From: [Larned, Kimberly - FS, WA](#)
To: [Chace Pedersen](#)
Cc: [Rausch, Joseph - FS, WA](#)
Subject: RE: [External Email]CU-23-00002 The Outpost - Notice of Application
Date: Wednesday, November 15, 2023 3:04:58 PM
Attachments: [image001.png](#)
[image002.png](#)
[image003.png](#)
[image004.png](#)

Subject: [External Email]CU-23-00002 The Outpost - Notice of Application

CDS is requesting comment on the following conditional use application: CU-23-00002 The Outpost. Links to the file materials can be found below. The comment period will end **Friday, December 1, 2023, at 5pm**. CDS will assume your agency does not wish to provide comment if not received by this date. Please let me know if you have any issues accessing the materials.

**CONCEPTUAL SITE PLAN
MULTIPLE PARCELS**

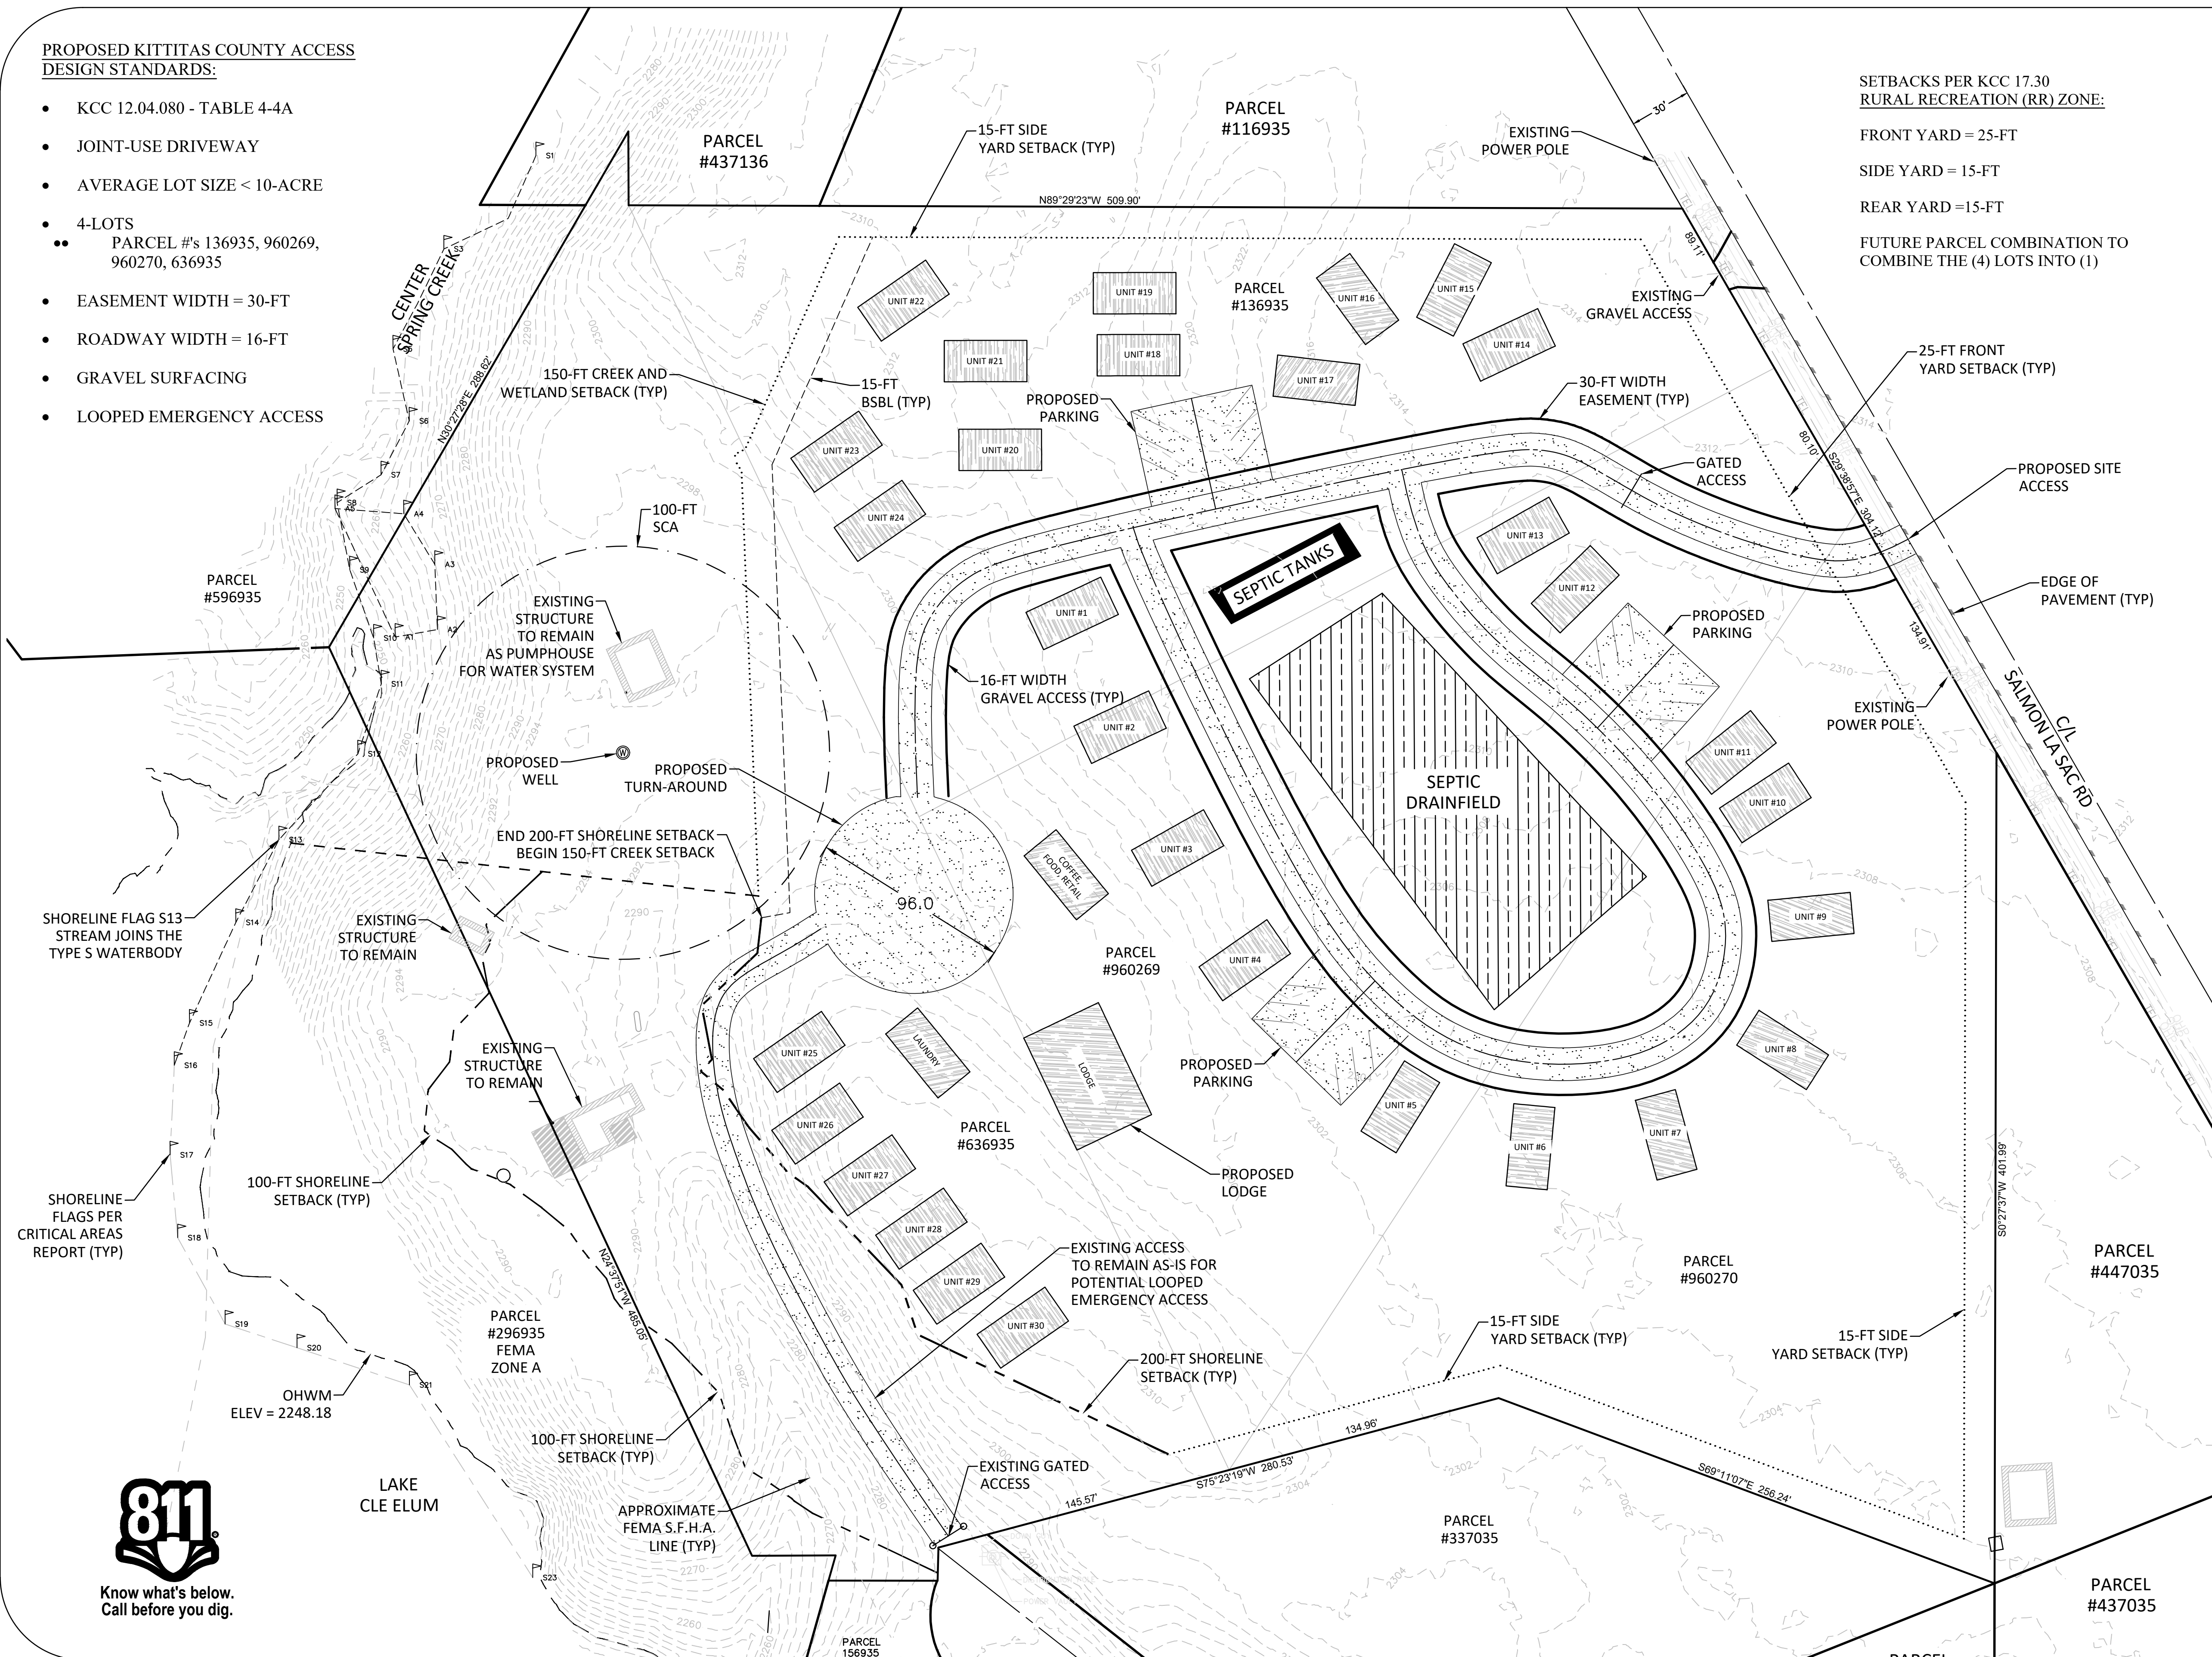
It appears that there may be an encroachment from parcel 636935 onto National Forest System Lands. It's difficult to know the extent of the encroachment without a survey of that line. Please request the landowner to complete a survey of the line between National Forest and their parcel.

Do not allow further development of these parcels until existing encroachments (if found) are removed from National Forest System Lands.

Enforce setbacks to ensure those structures or any future structures are not being proposed on National Forest lands.
